**MASTER DEVELOPMENT
DRAINAGE PLAN
FOR
DAVIS RANCH SKETCH PLAN,
EL PASO COUNTY, COLORADO**

June 2023

SKP232

EXISTING DRAINAGE MAP
 DAVIS RANCH
 JOB NO. 25274.00
 06/29/23
 SHEET 1 OF 1

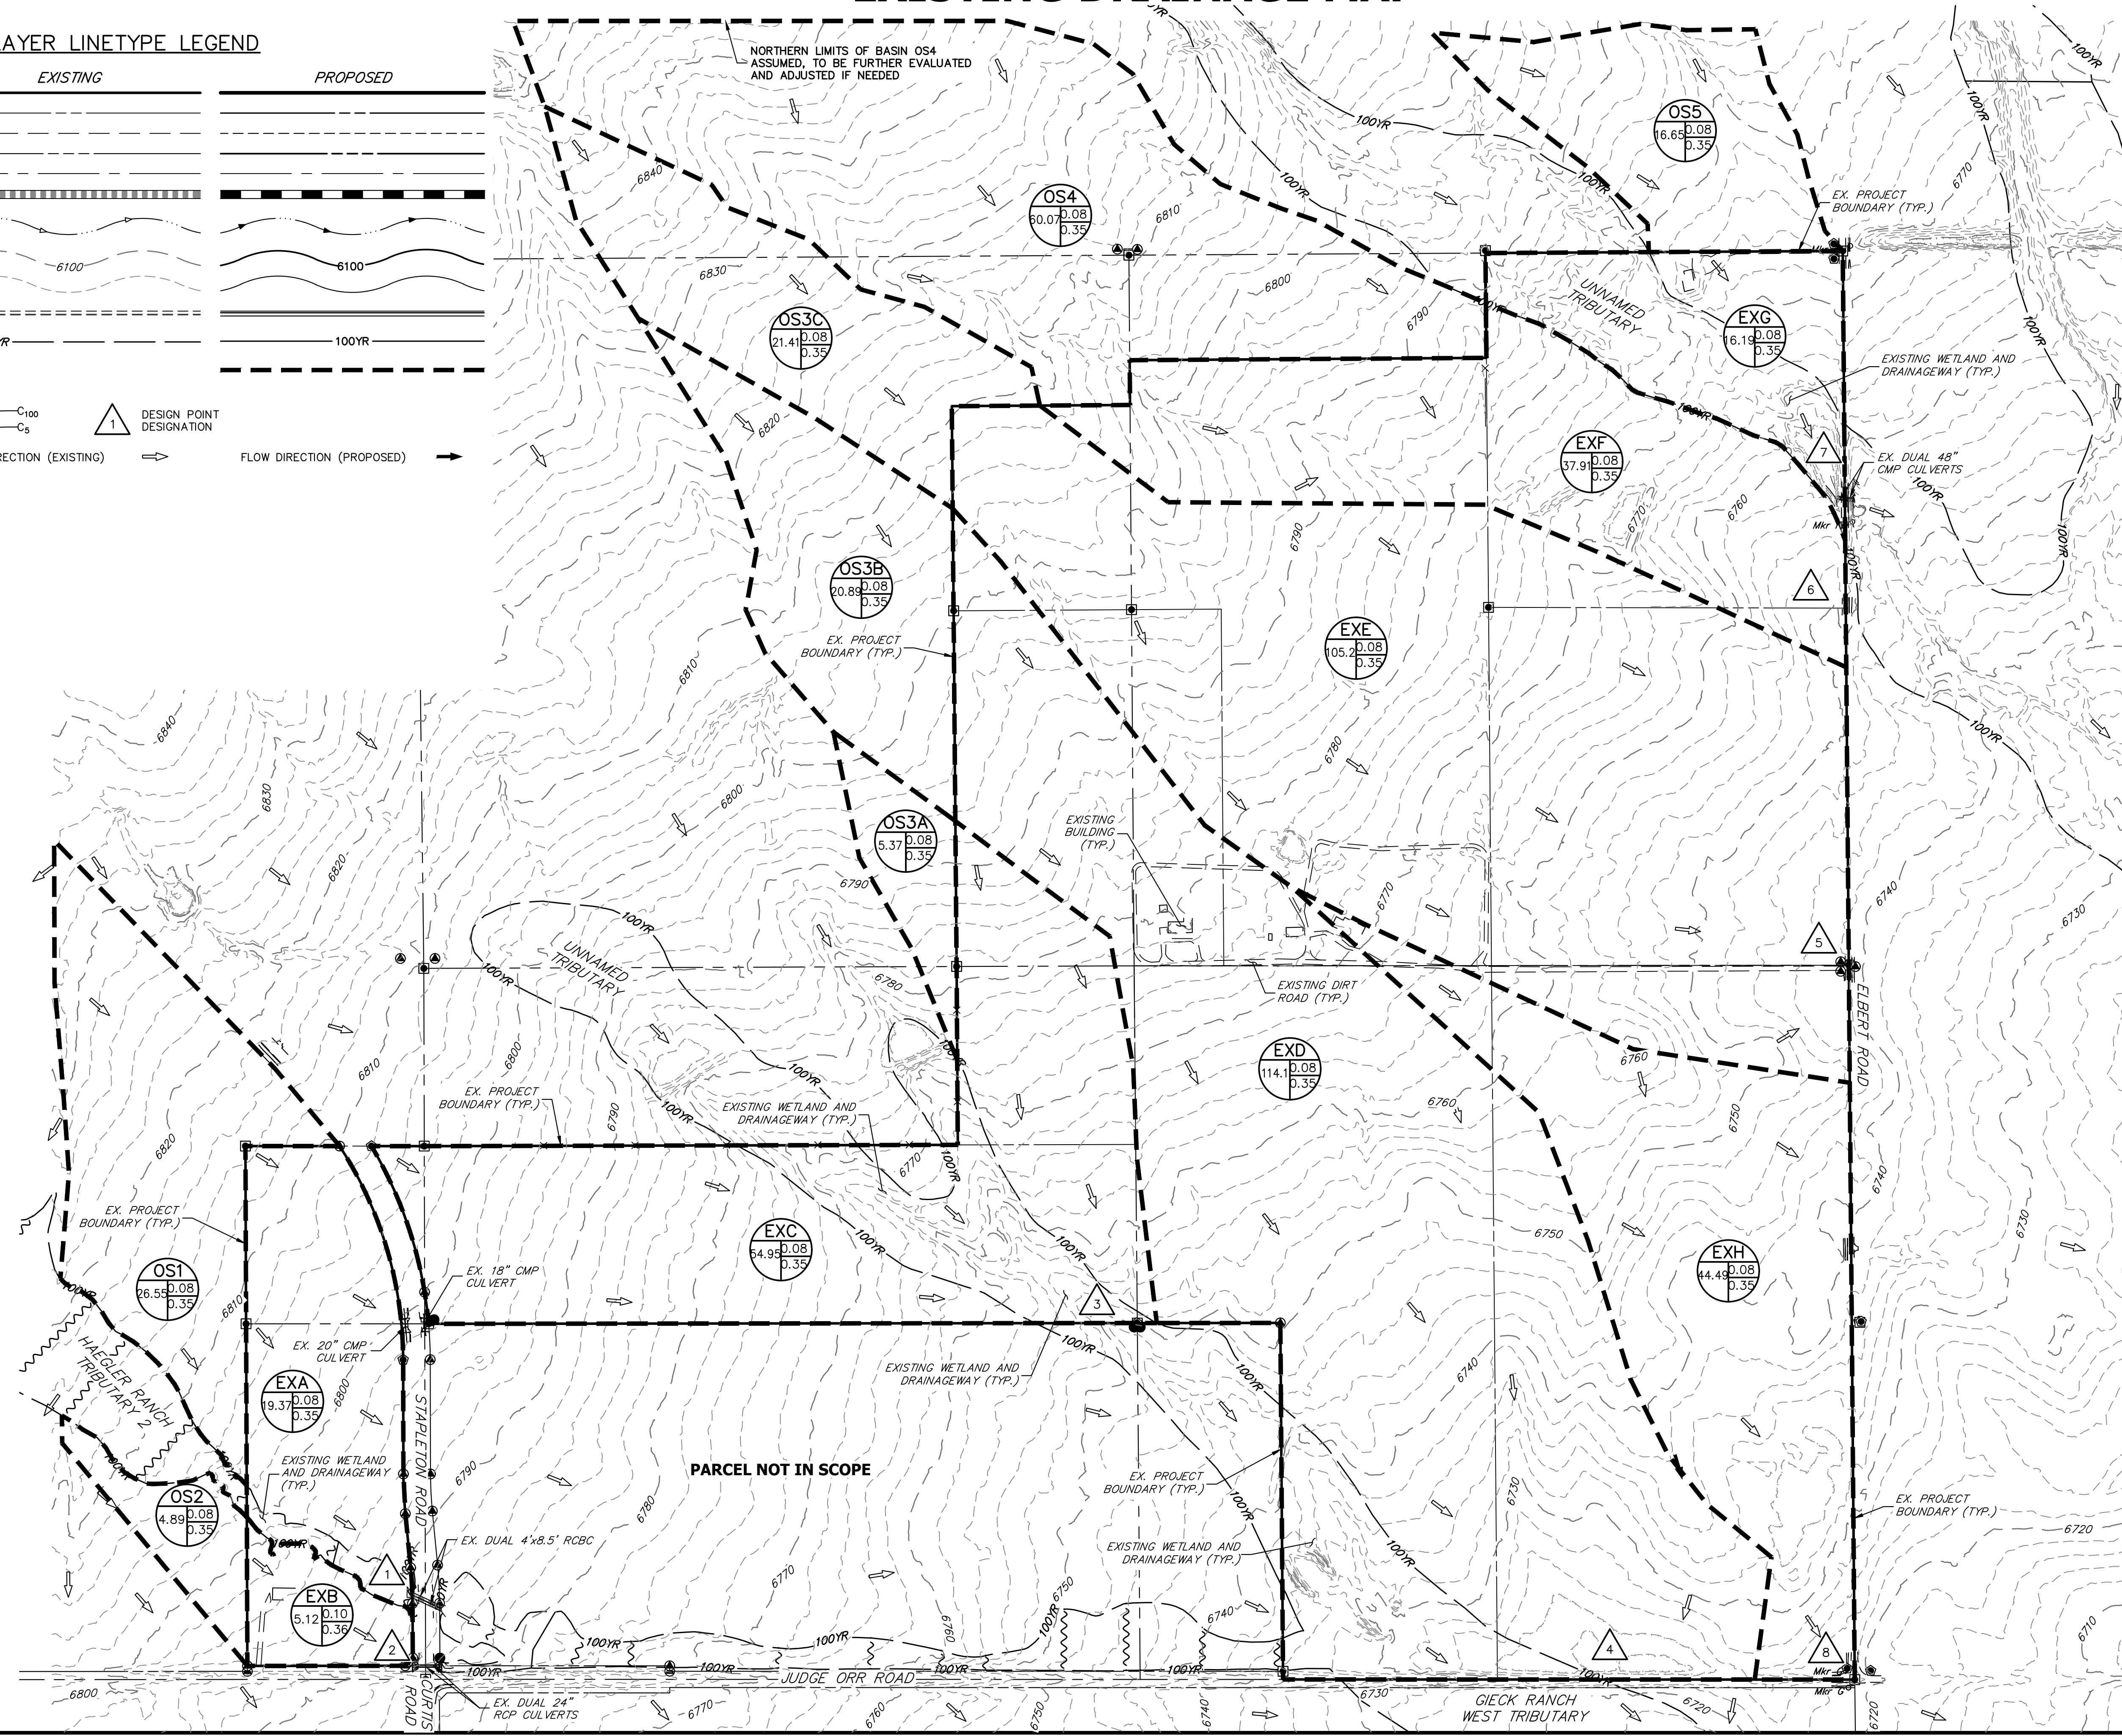
Provide hydrologic analysis of the existing & proposed conditions providing the peak flows of each basin and at the design points. Be sure to include flows from the various drainageways throughout the site.

PROPOSED DRAINAGE MAP
DAVIS RANCH
JOB NO. 25274.00
06/30/23
SHEET 1 OF 1

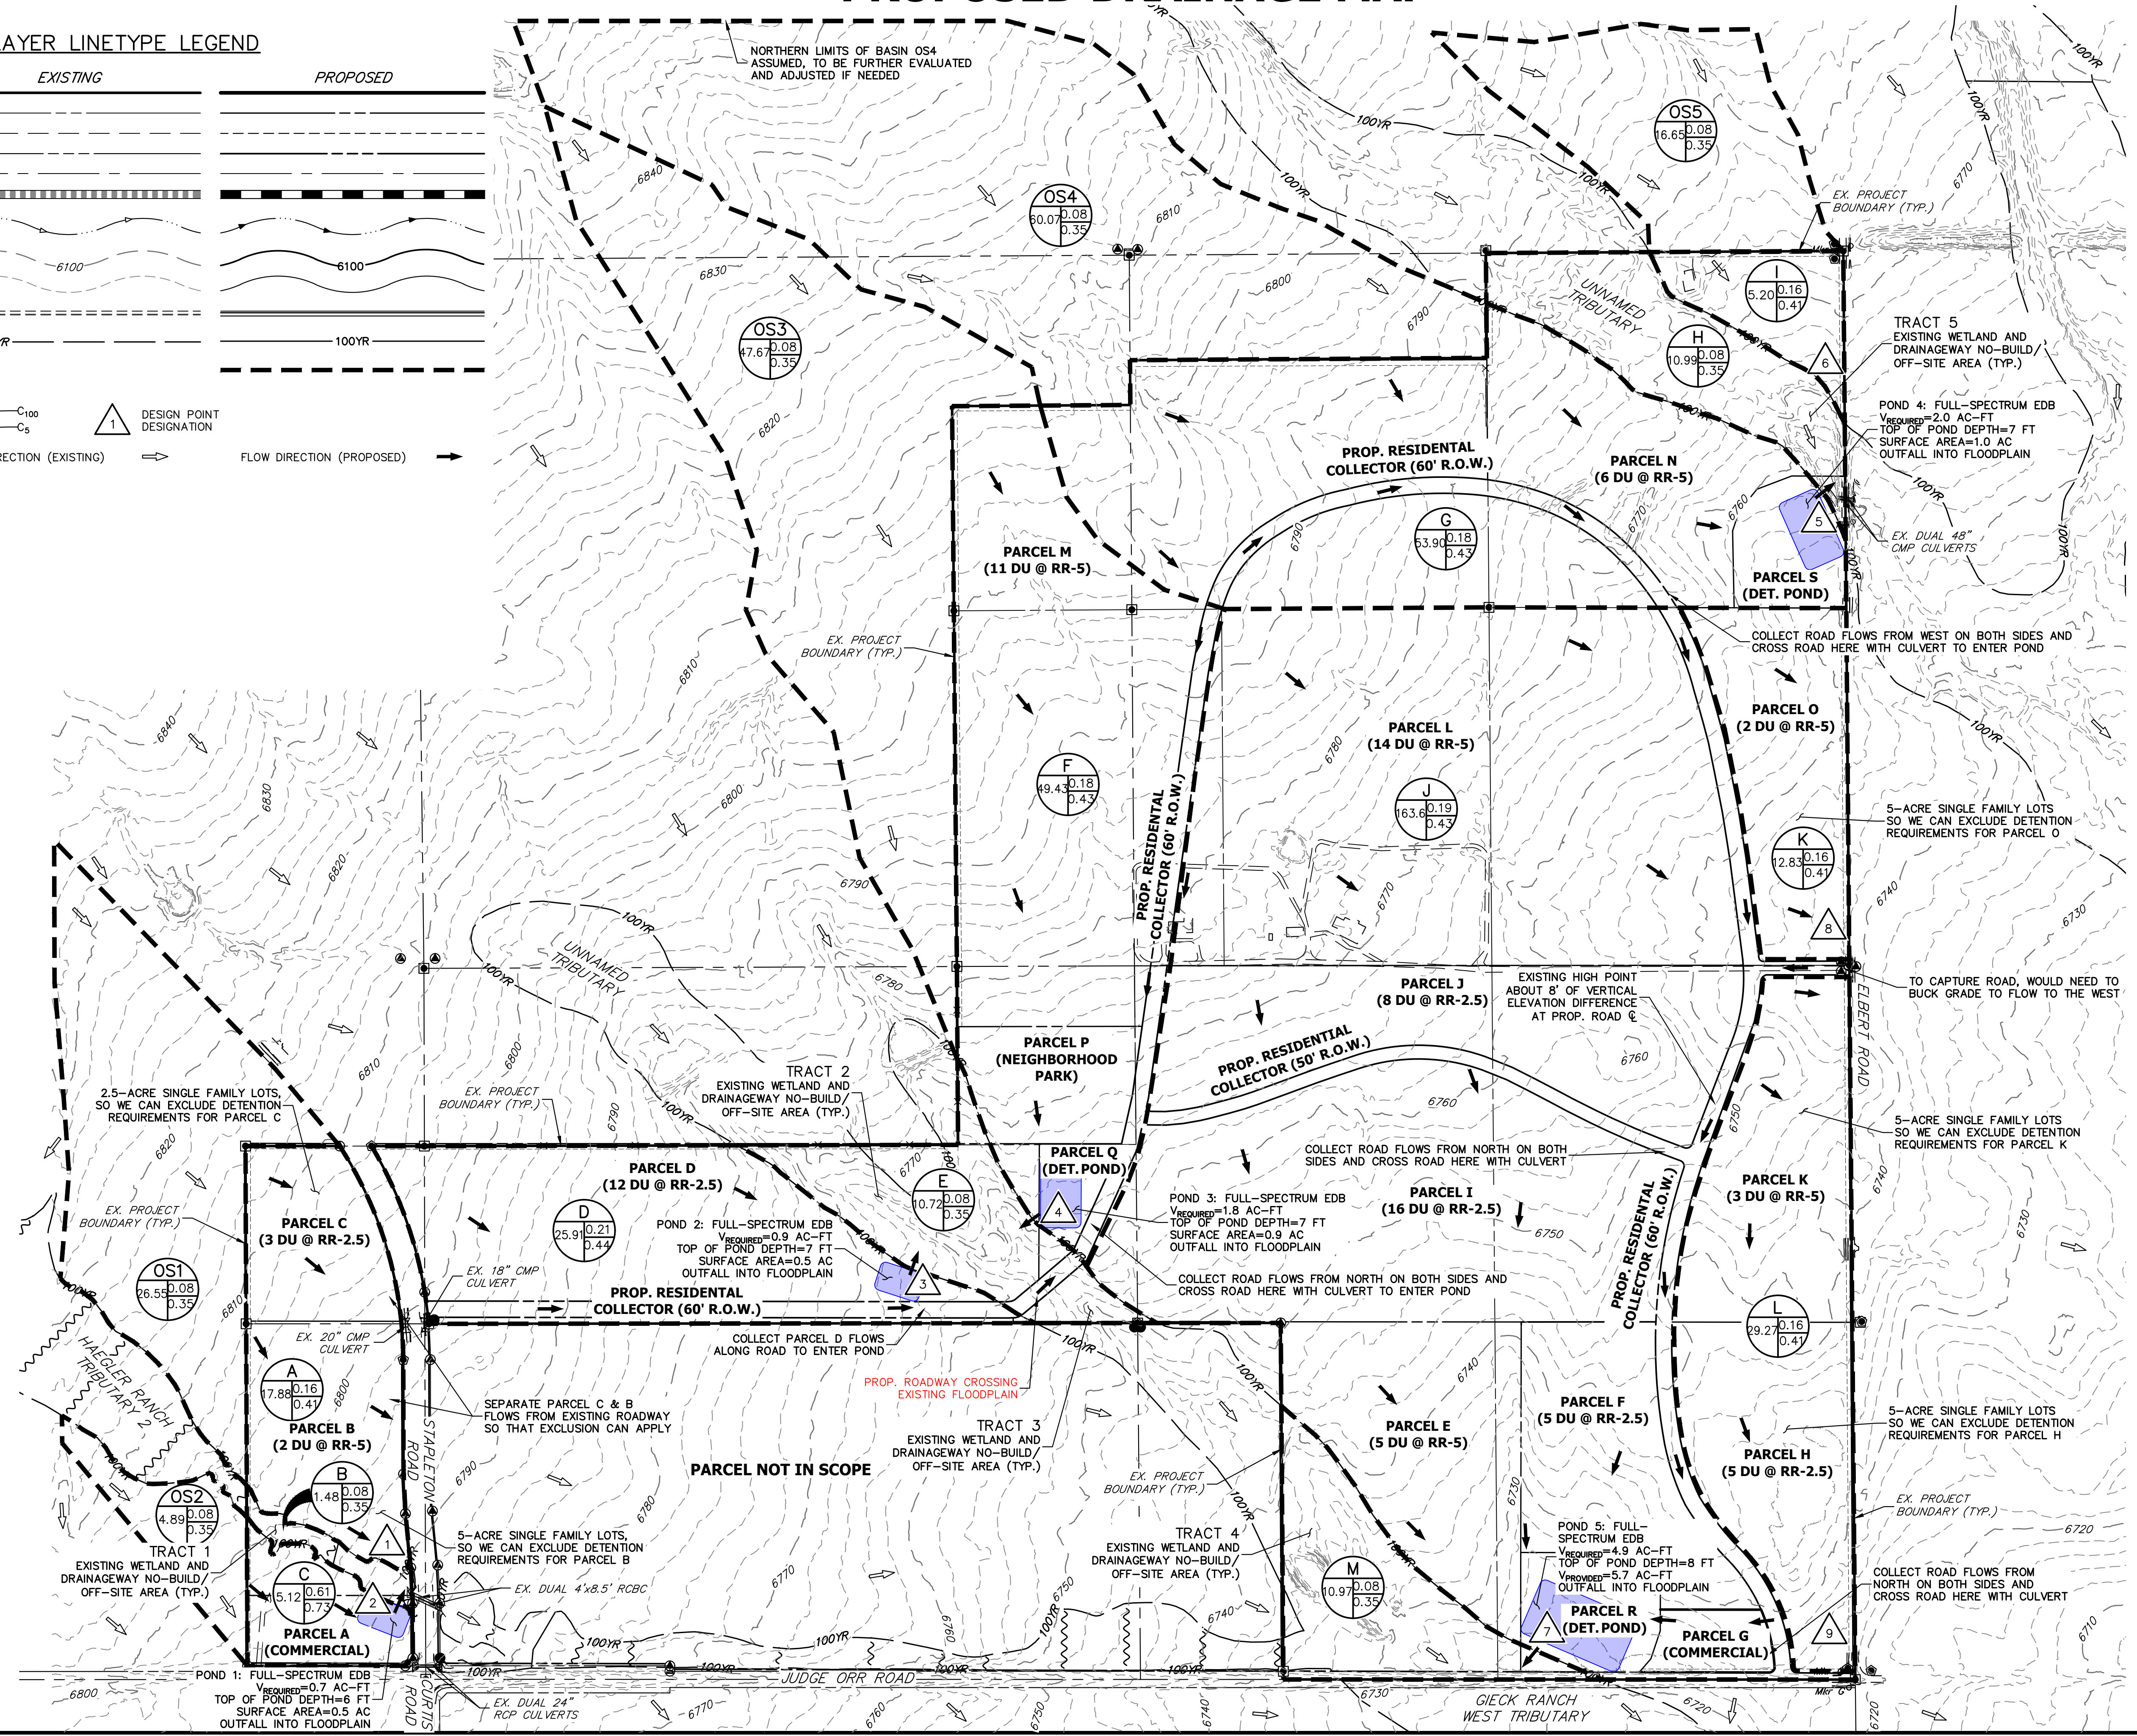
This exclusion is for water quality only. Increase in flows for this basin will still have to be mitigated. Please discuss mitigation measures or why they are not needed for this basin.

this should be 4'x8.5' RCBC as indicated
in the drainage plan and as discussed
previously in the narrative. Revise.

The drainage way does not extend to DP9. Indicate how the flows are conveyed downstream.
